Ref: GOOS3000

MINOR-MATERIAL AMENDMENT APPLICATION (SECTION 73)
UNIT 3A, EAST HORNDON BUSINESS PARK, TILBURY ROAD, WEST HORNDON

On behalf of our client, Goodman, we are pleased to submit an application for a Minor-Material Amendment (Section 73) in relation to full planning permission ref. 22/01751/FUL which approved the construction of a Class B2 / B8 building at the site Land South of East Horndon Hall, Tilbury Road, West Horndon, Essex, CM13 3LR.

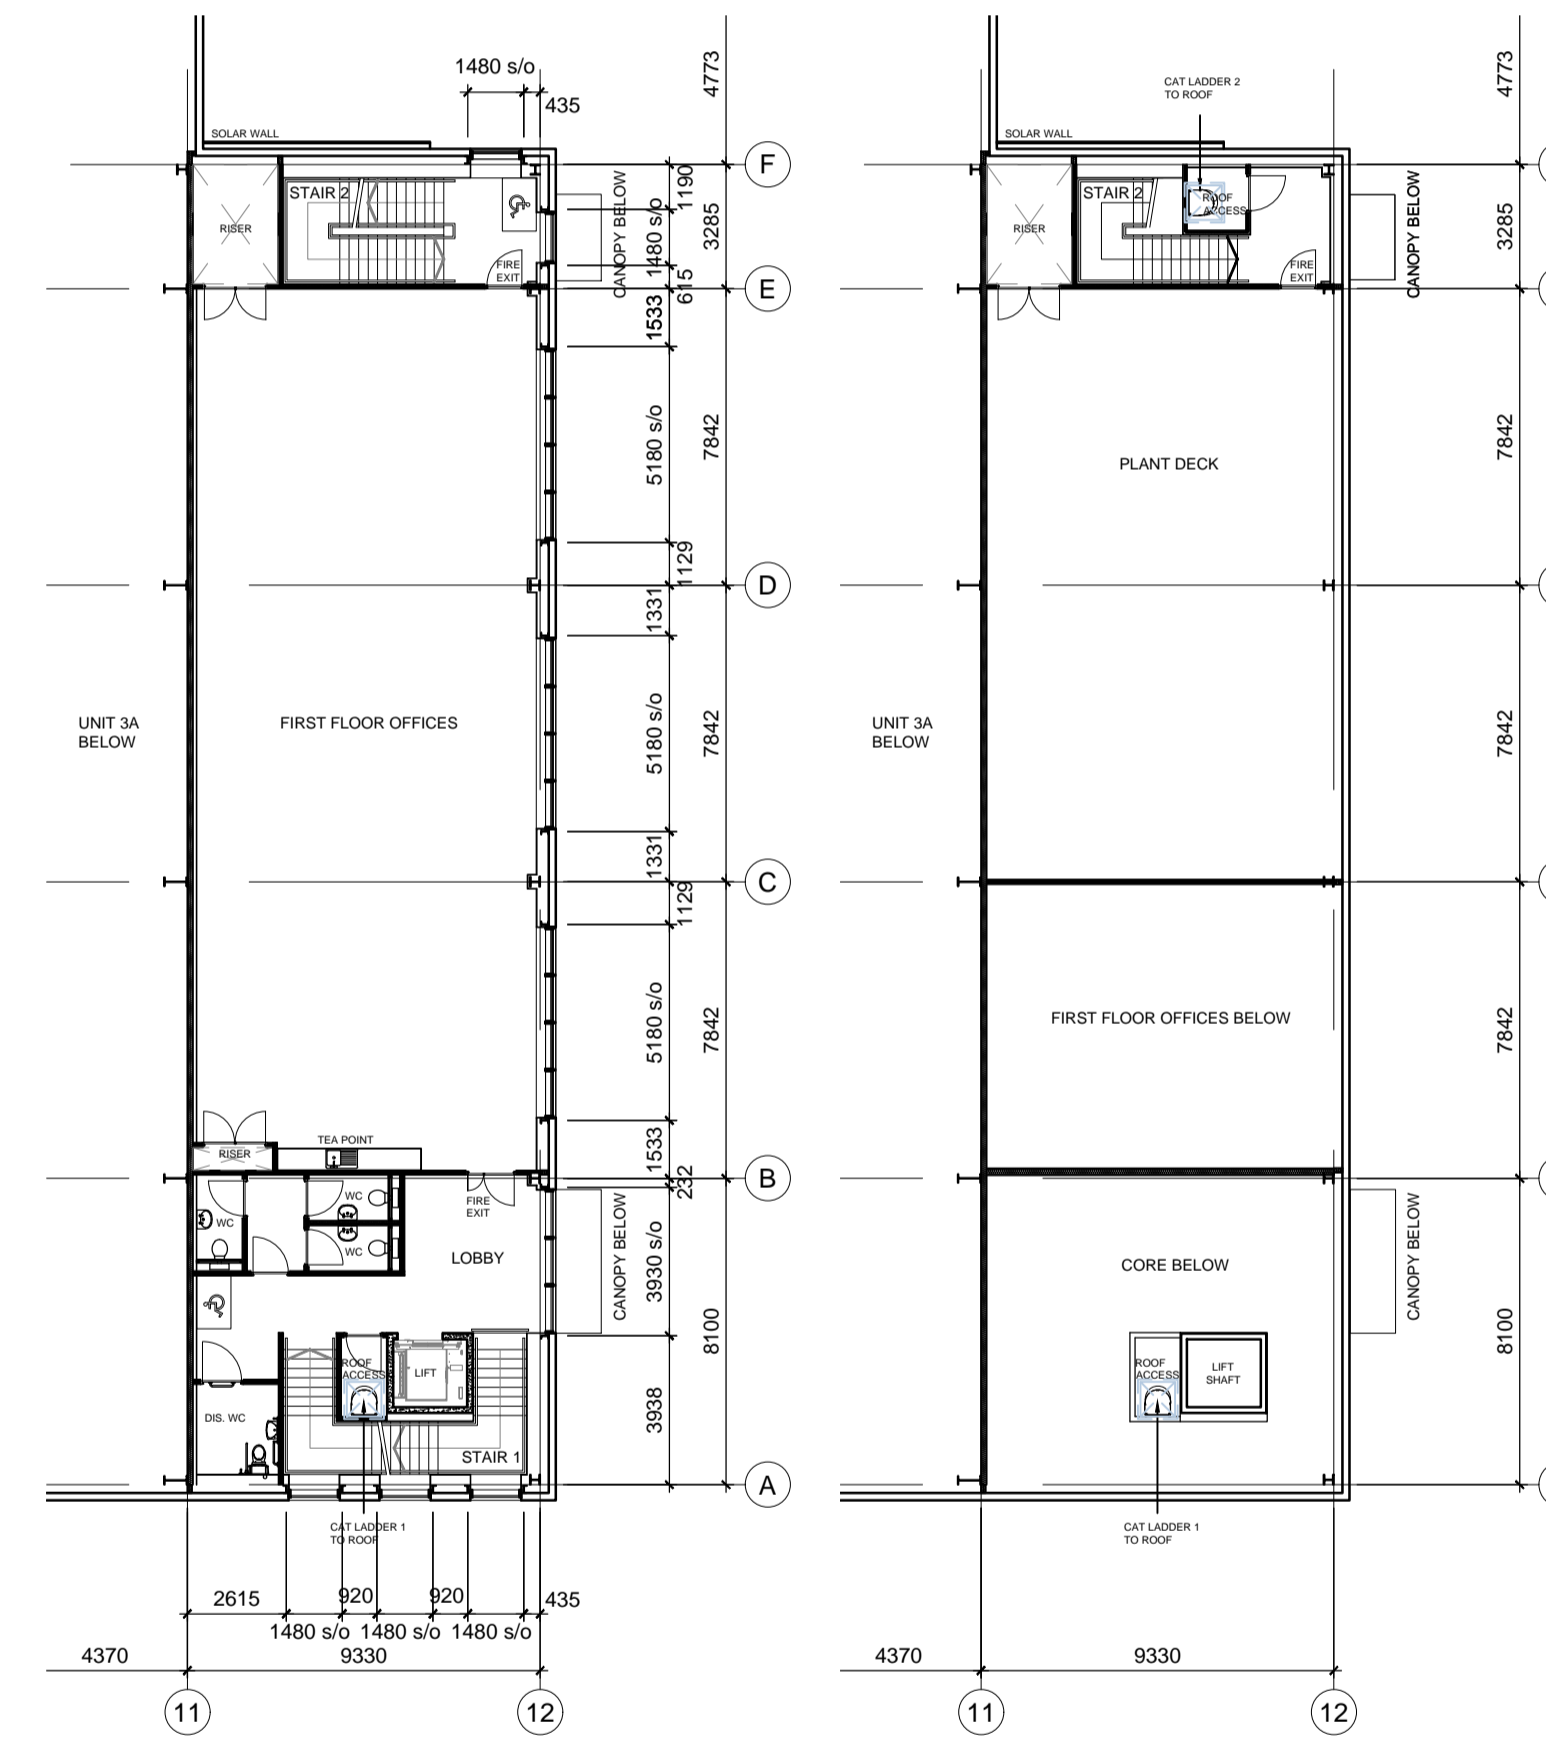
The new occupier requires an enlarged mezzanine area in order to provide additional flexibility for future operations within the building. The mezzanine also takes into account minor changes to the internal configuration of the ground floor including the formation of an ancillary customer area. This change is internal only and does not affect the external appearance of the building.

It is acknowledged that this internal change will result in an increased area of floorspace, with the addition of 774 sqm, resulting in a total building floor space of 5,496 sqm.

DRAWING NUMBER
31795-FE-14C

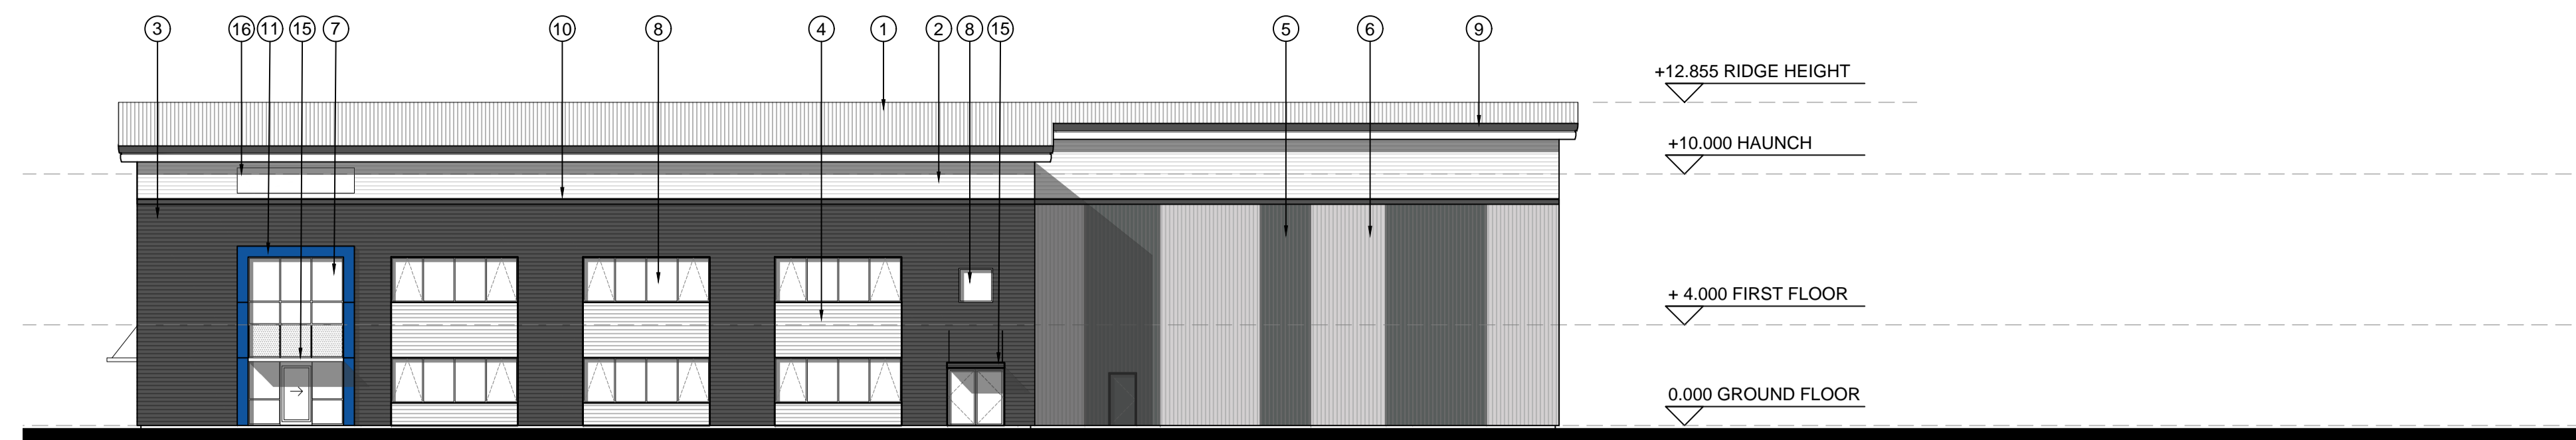
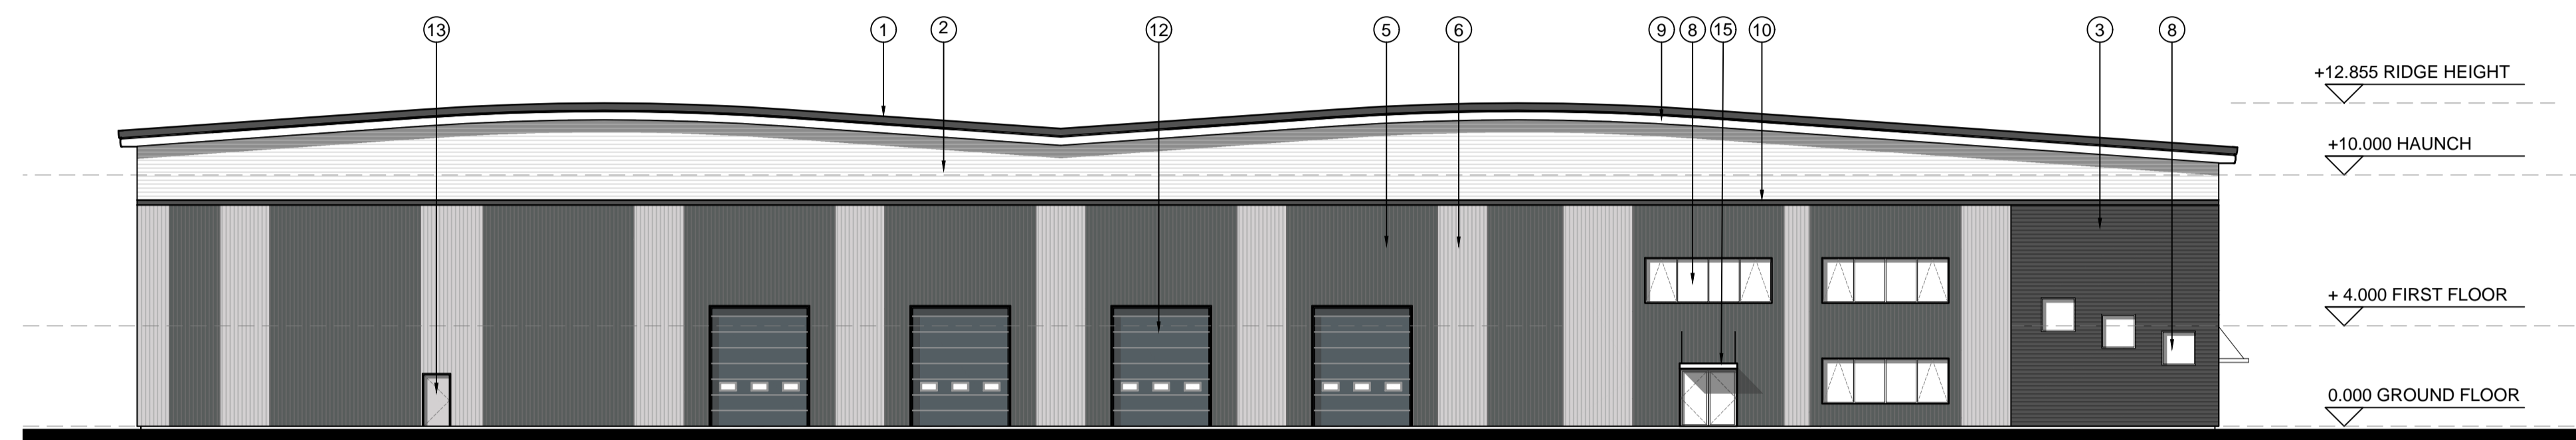
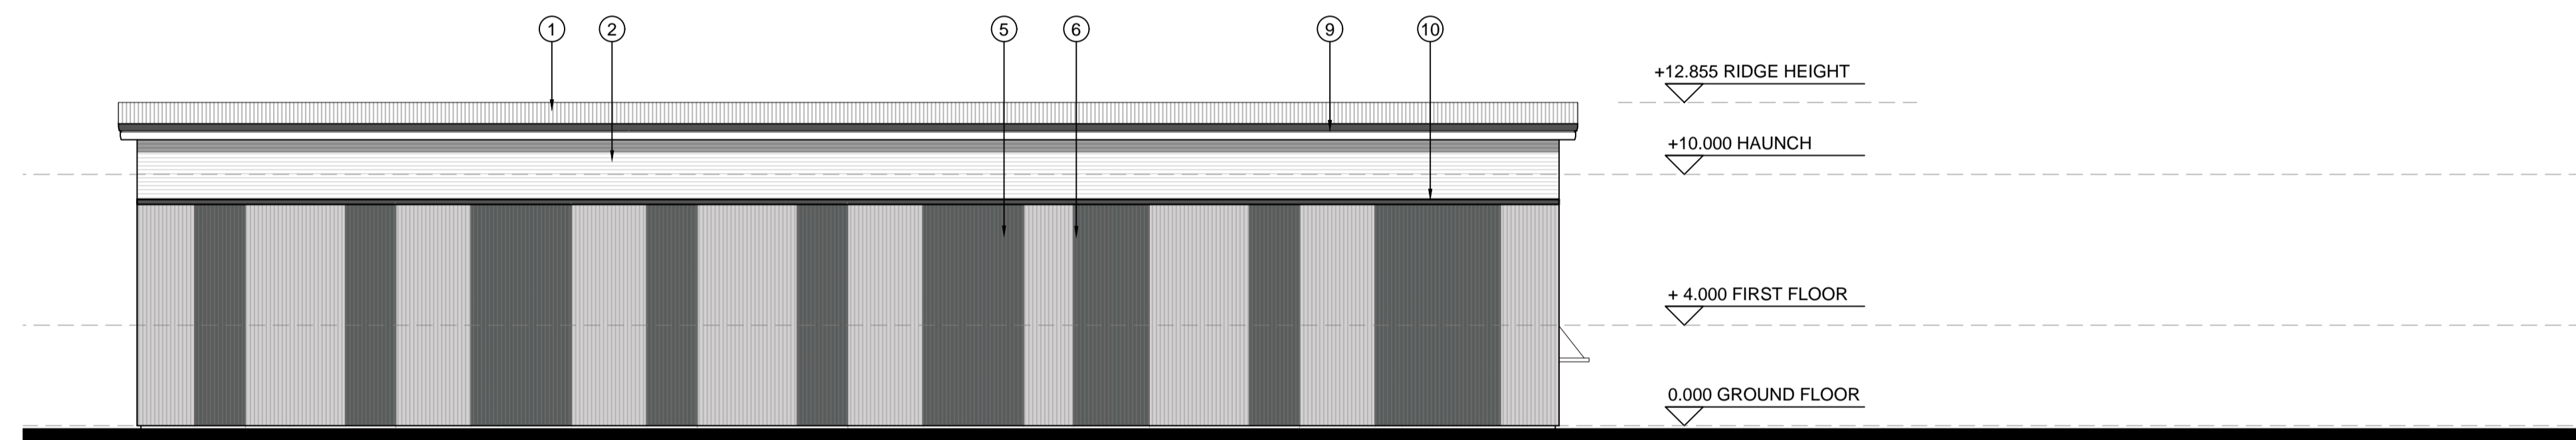
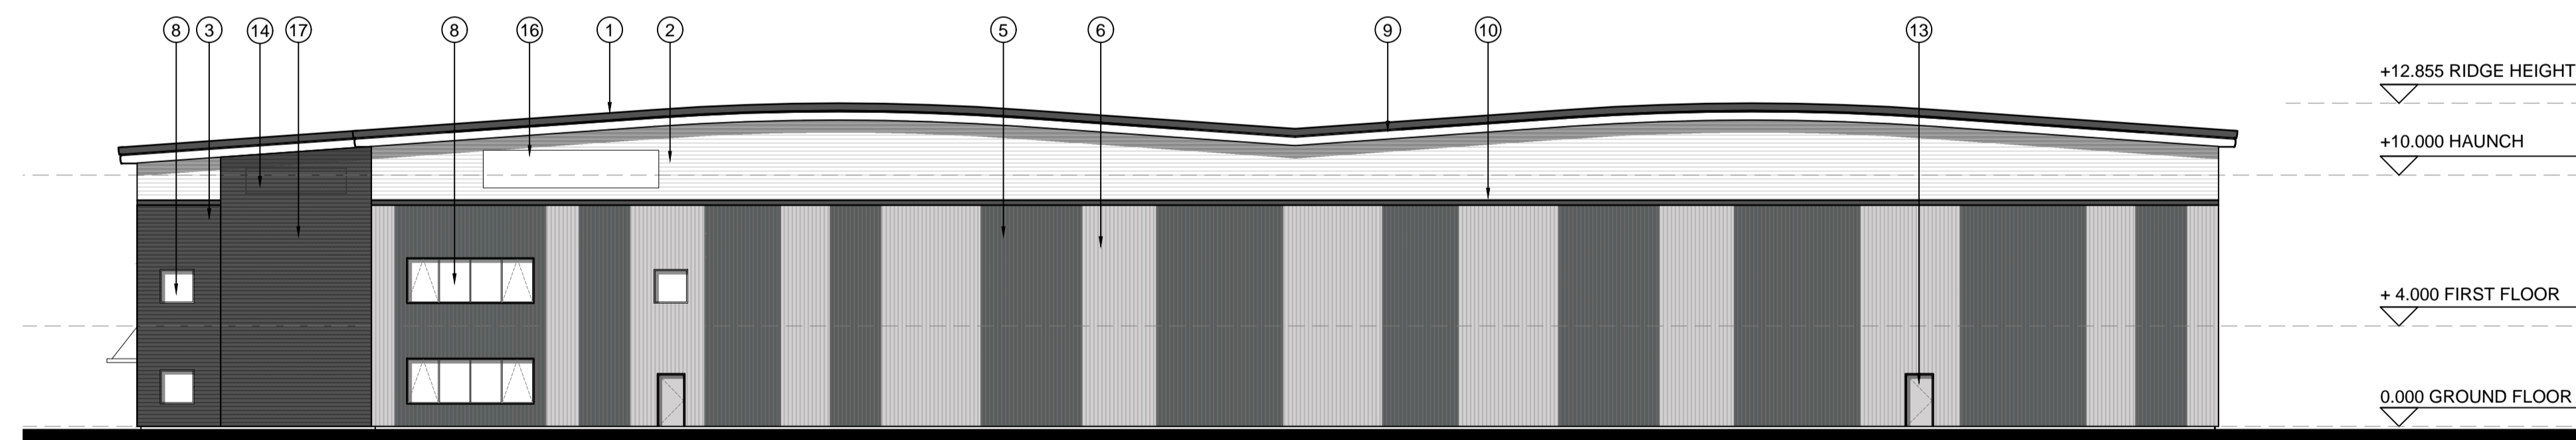
- Provision of 774 sqm additional mezzanine floorspace at the first floor (to comprise B8 floorspace and ancillary office).
- Provision of three new windows and incorporation of a larger door on the northeast elevation.

- Provision of three new windows on the southwest elevation.
- Change in the colour of the office feature flashing at the building entrance from green to blue.

The six additional windows, as highlighted above, will provide enhanced daylight into the interior of the building, resulting in an improved working environment, and will also result in a more interesting external appearance of the building. The location of these windows are show on the submitted Elevation Plan (ref. 31795-FE-14 rev C) and will not result in any amenity issues such as overlooking.

The change to the feature colour of the building entrance, from green to blue, is required to reflect the branding colours of the new intended occupier. It was always anticipated that the colour of the building would need to change to reflect the specific occupier, and the green shown on the original plans acted as a place holder. The signage across East Horndon Business Park will still be consistent across all areas of the Park, providing a clear visual identity of this Business Park, despite the various occupiers within.
